Portishead Branch Line (MetroWest Phase 1)

Planning Inspectorate Reference: TR040011

9.3.11 ExA.SoCG-ASP.D1.V1 – Statement of Common Ground

- (1) North Somerset District Council; and
- (2) Avon and Somerset Constabulary

674946.BQ.42.01-380 F
 Drawing Scale: 1:32000 @ A3

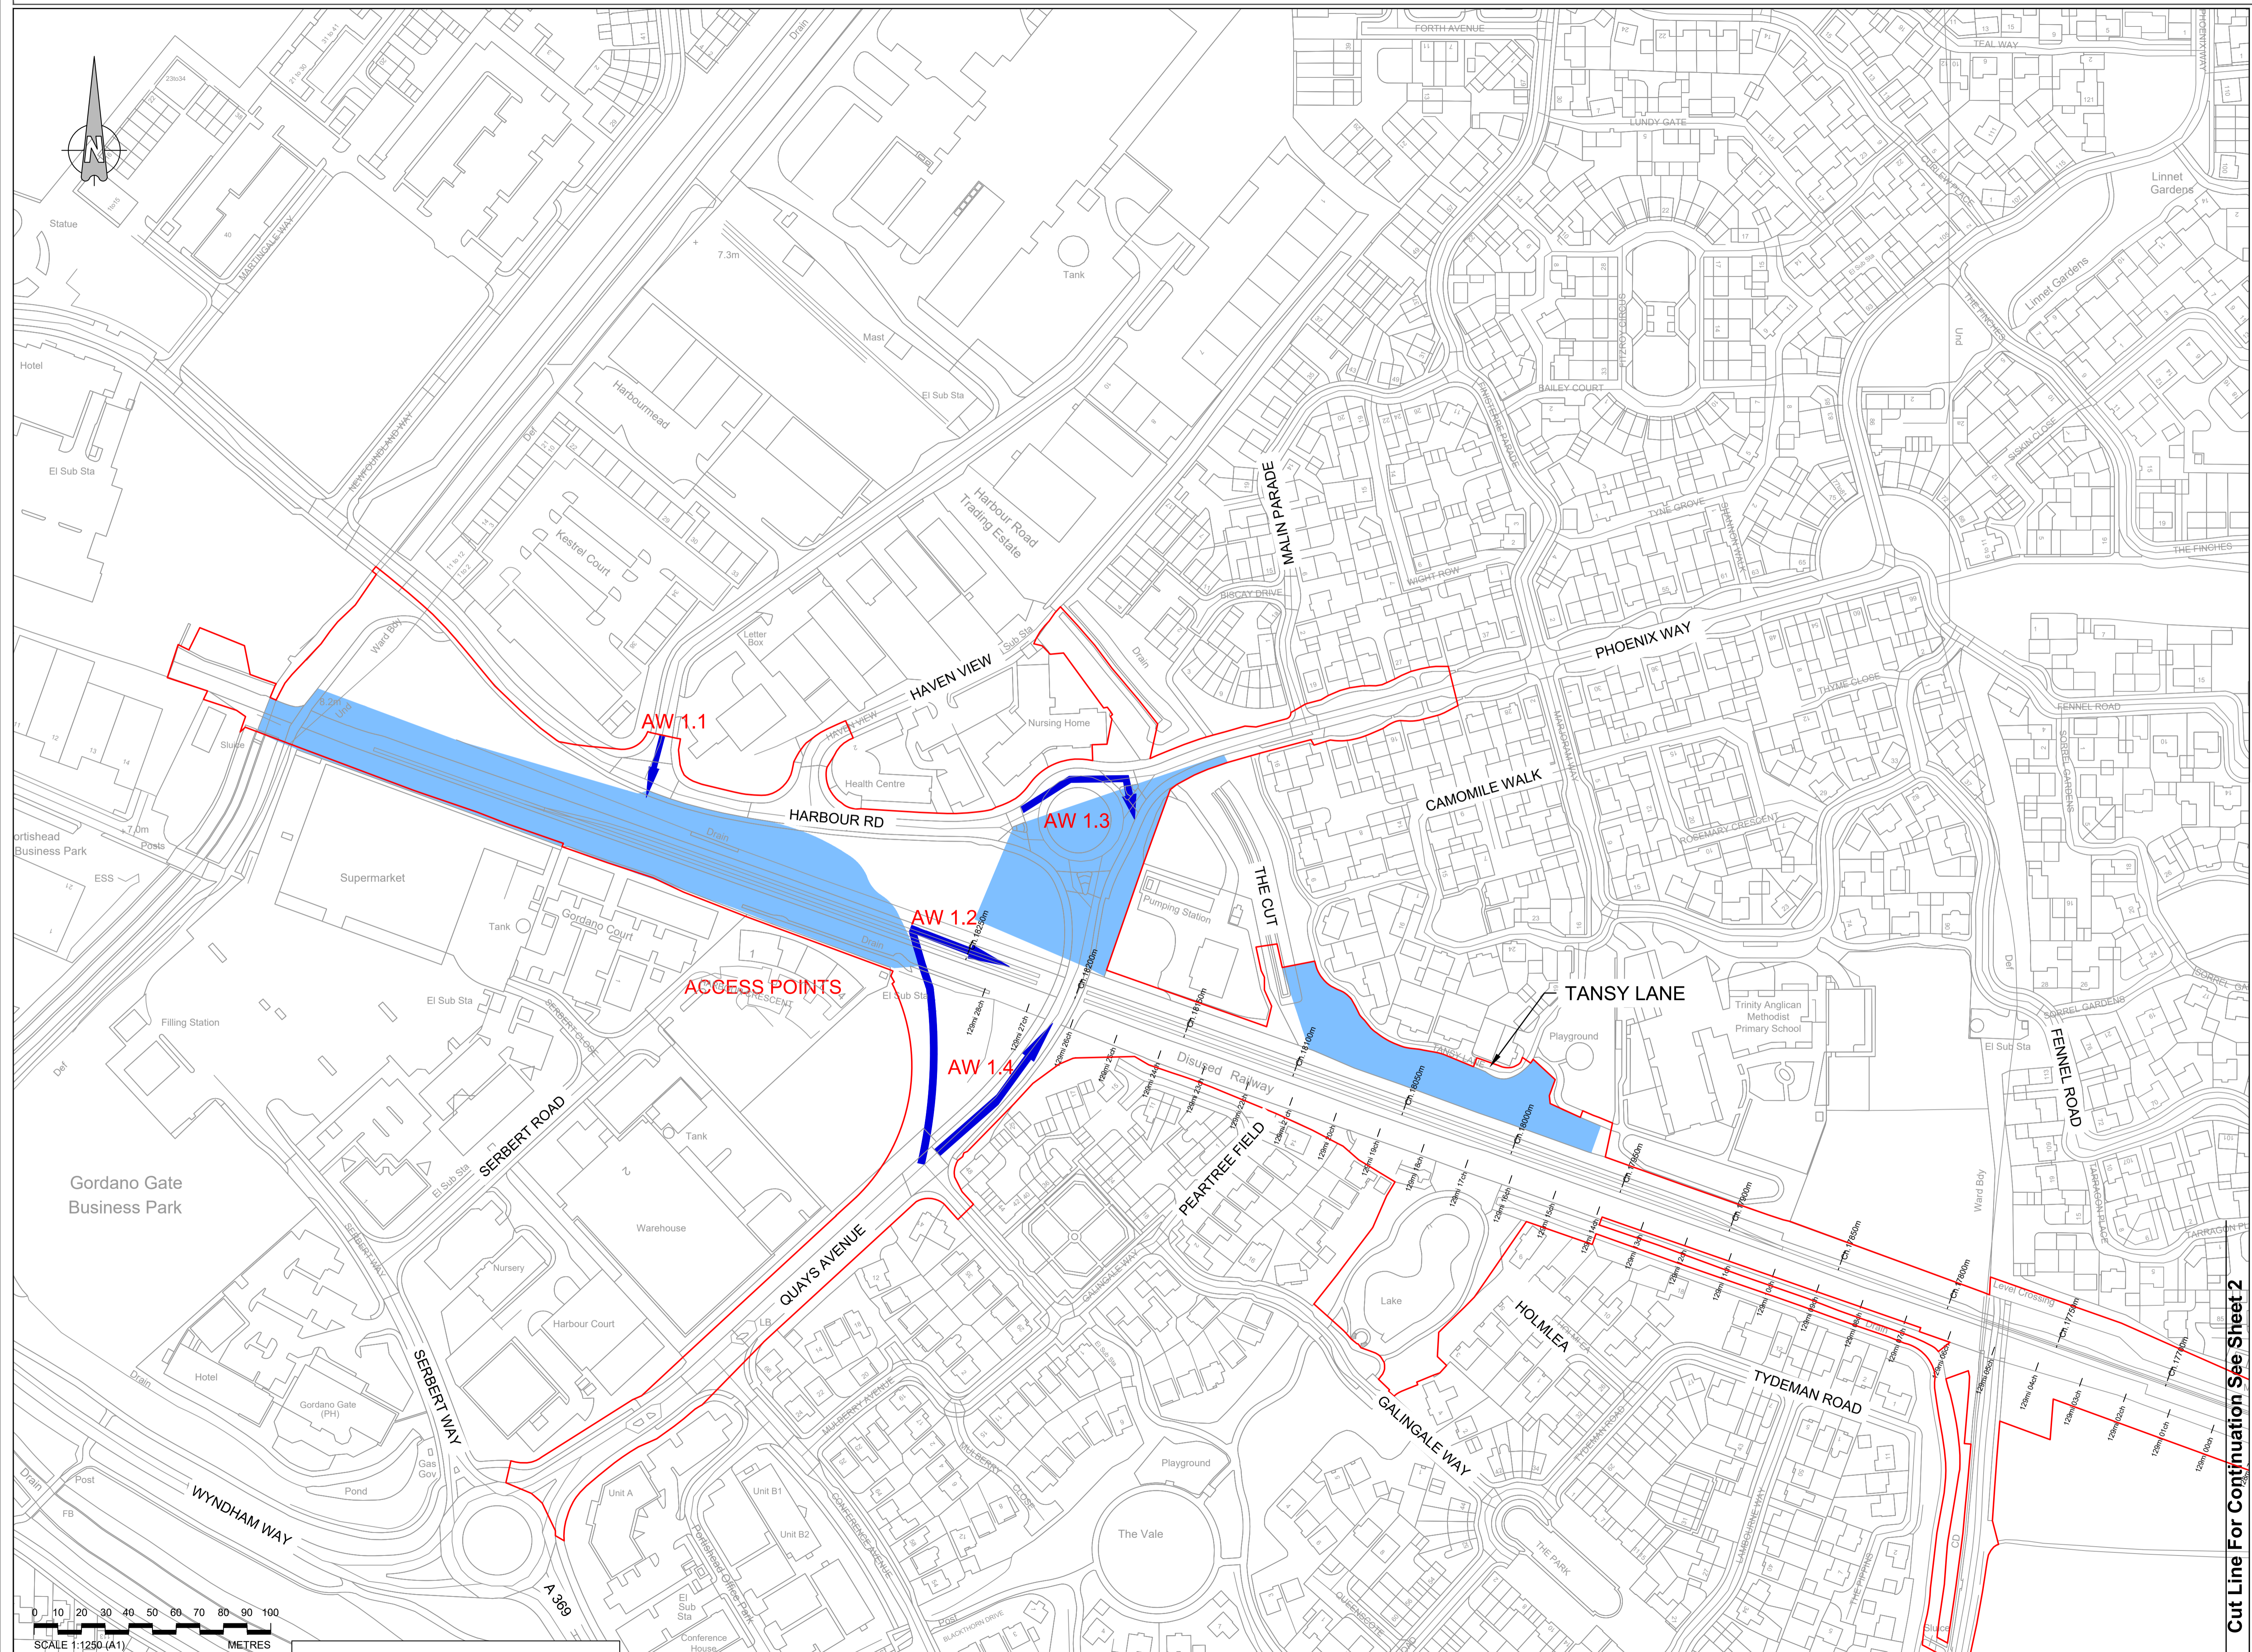
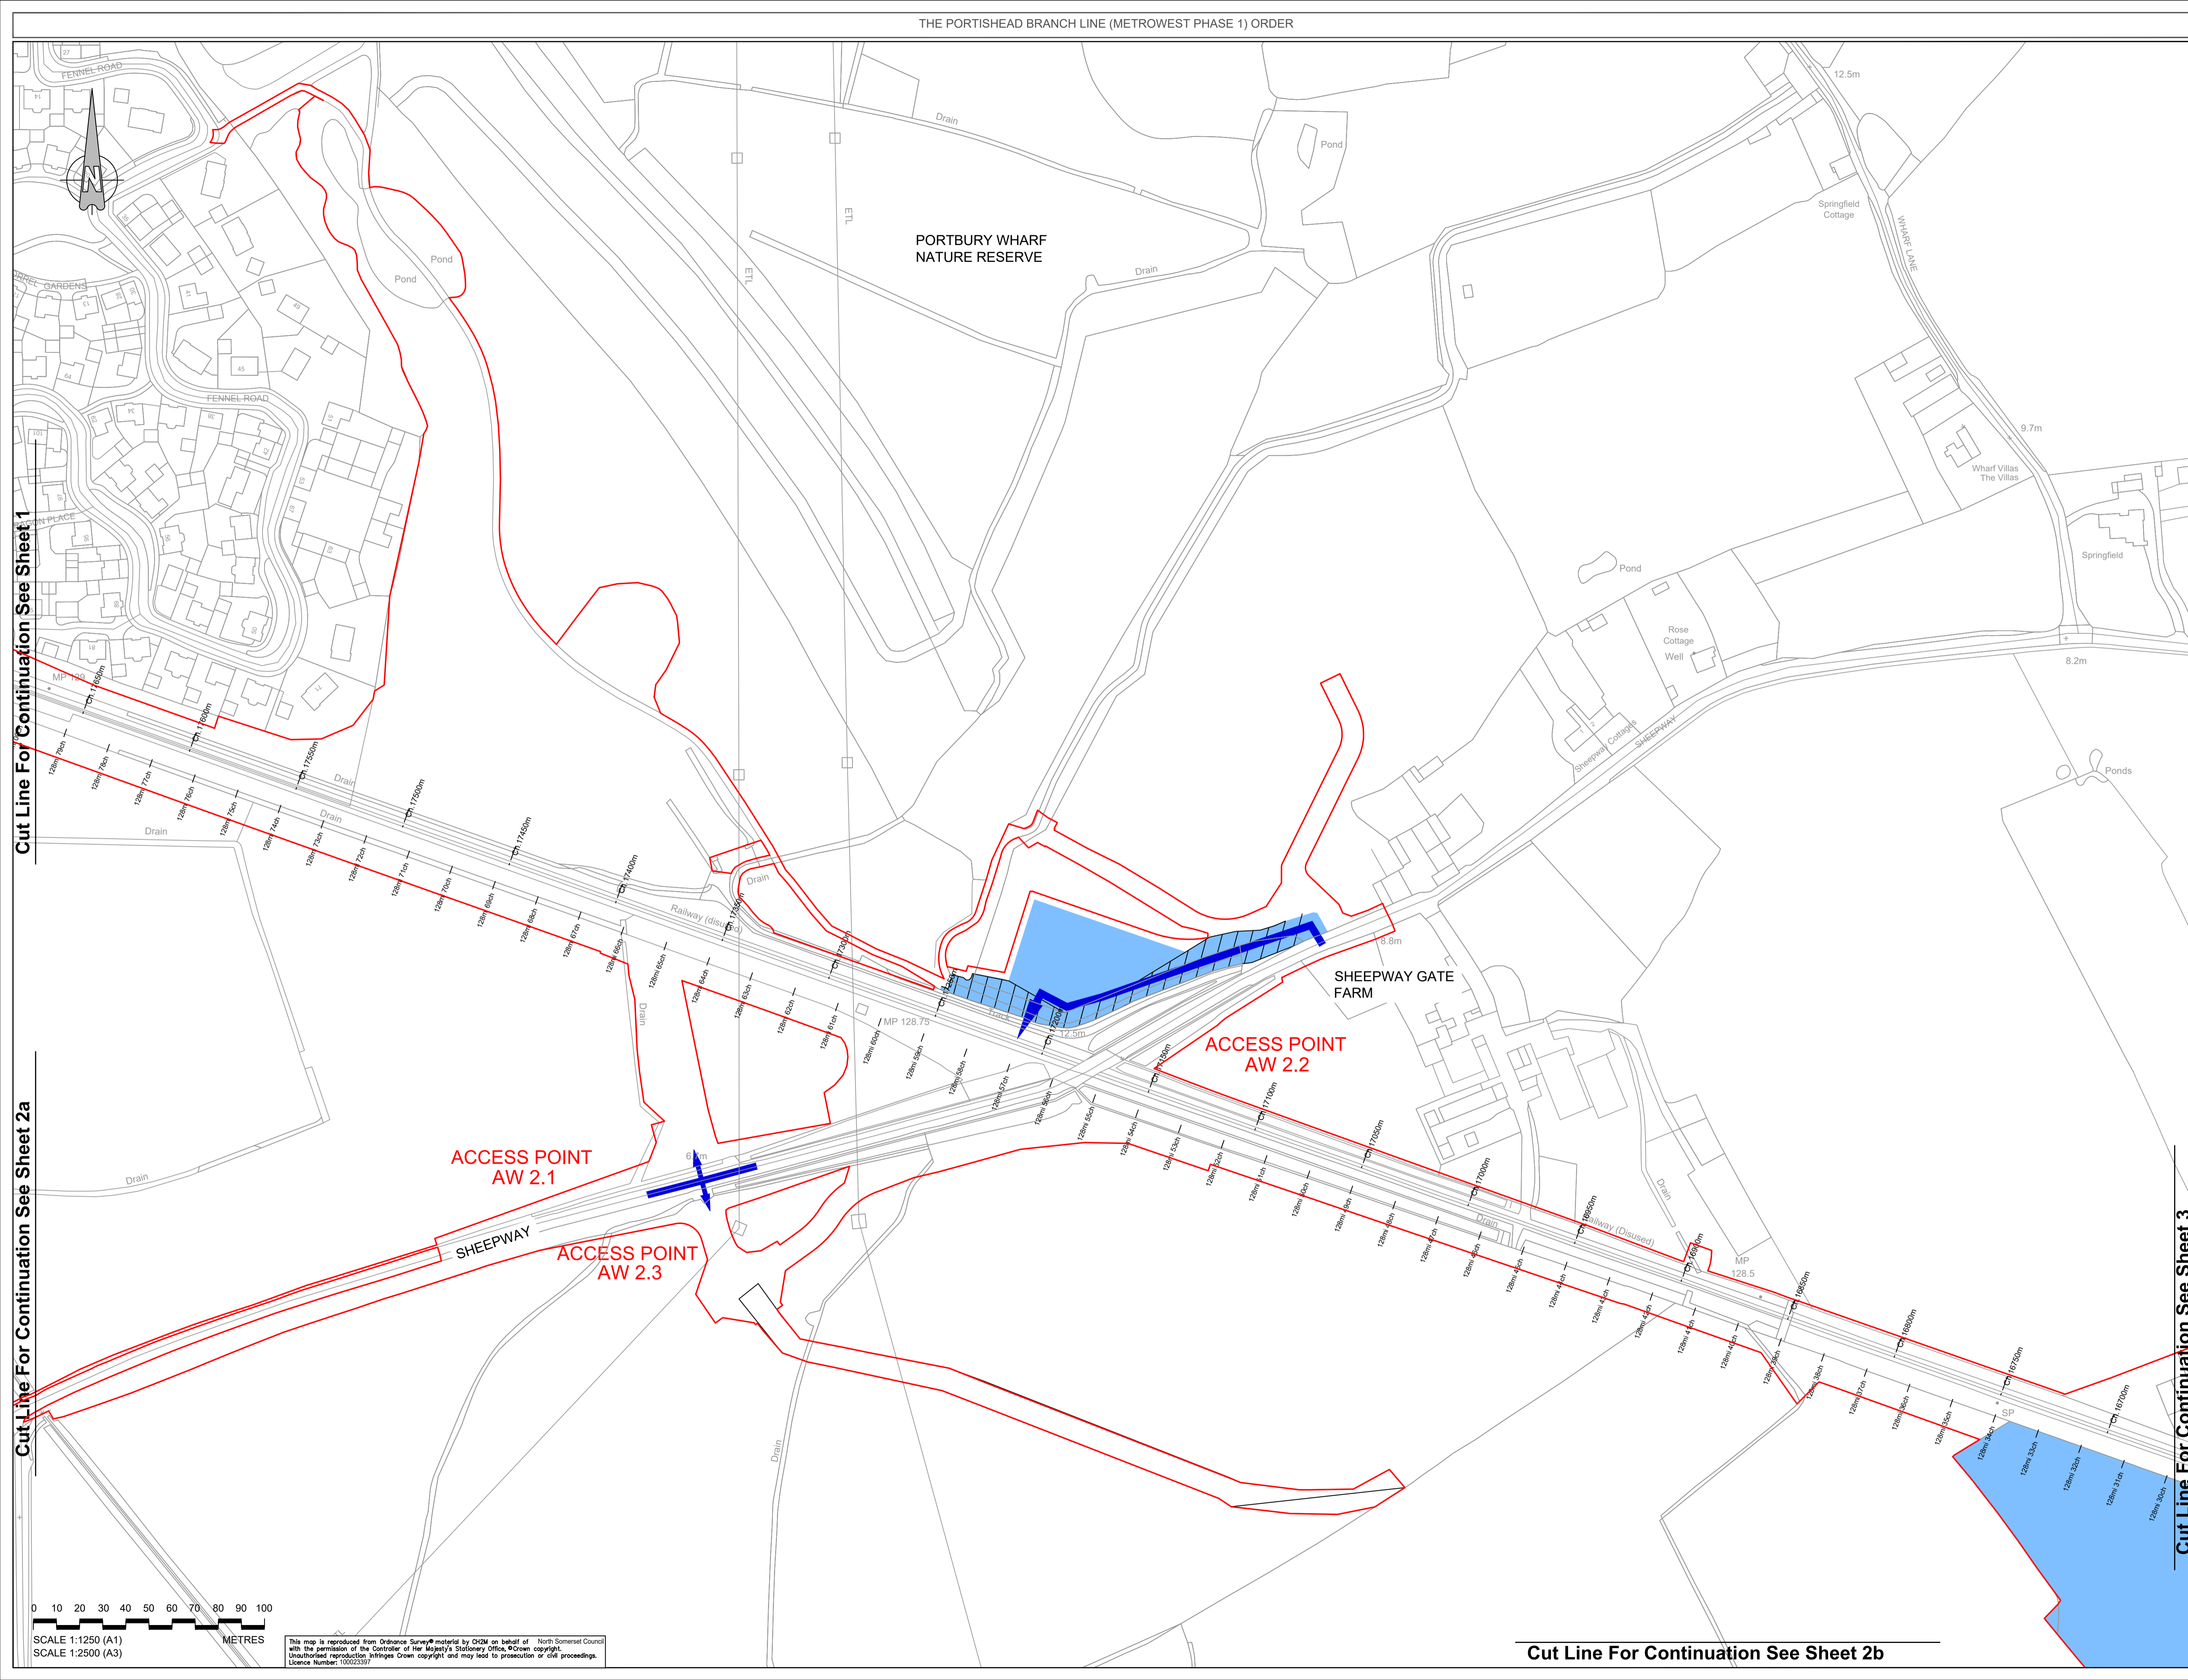
Topic	Avon and Somerset Constabulary position	Applicant position	Status
		emergency services to discuss the DCO Scheme on 7th March 2016 for which Avon and Somerset Constabulary were invited but sent their apologies; the Ambulance Service and Avon Fire and Rescue Service did attend.	
Emergency vehicle access	In all developments/Traffic Regulation Orders ("TROs") (whether temporary or permanent), we would always look for access for emergency vehicles where possible or, at a minimum, a suitable diversion with the ability to reach all areas.	Emergency access has been considered in both the TA (EA Appendix 16.1, DCO Document Reference 6.25) and the Code of Construction Practice ("CoCP") (DCO Document Reference 8.15), along with other traffic, parking and related issues. An Emergency Preparedness and Response Plan will provide a full list of management activities and communications channels with relevant parties. The contractor(s) will be required to liaise with the emergency services on the provision of site access points. The proposed accesses are shown on the Compounds, Haul Roads and Access to Works Plan (DCO Document Reference 2.29).	Agreed.
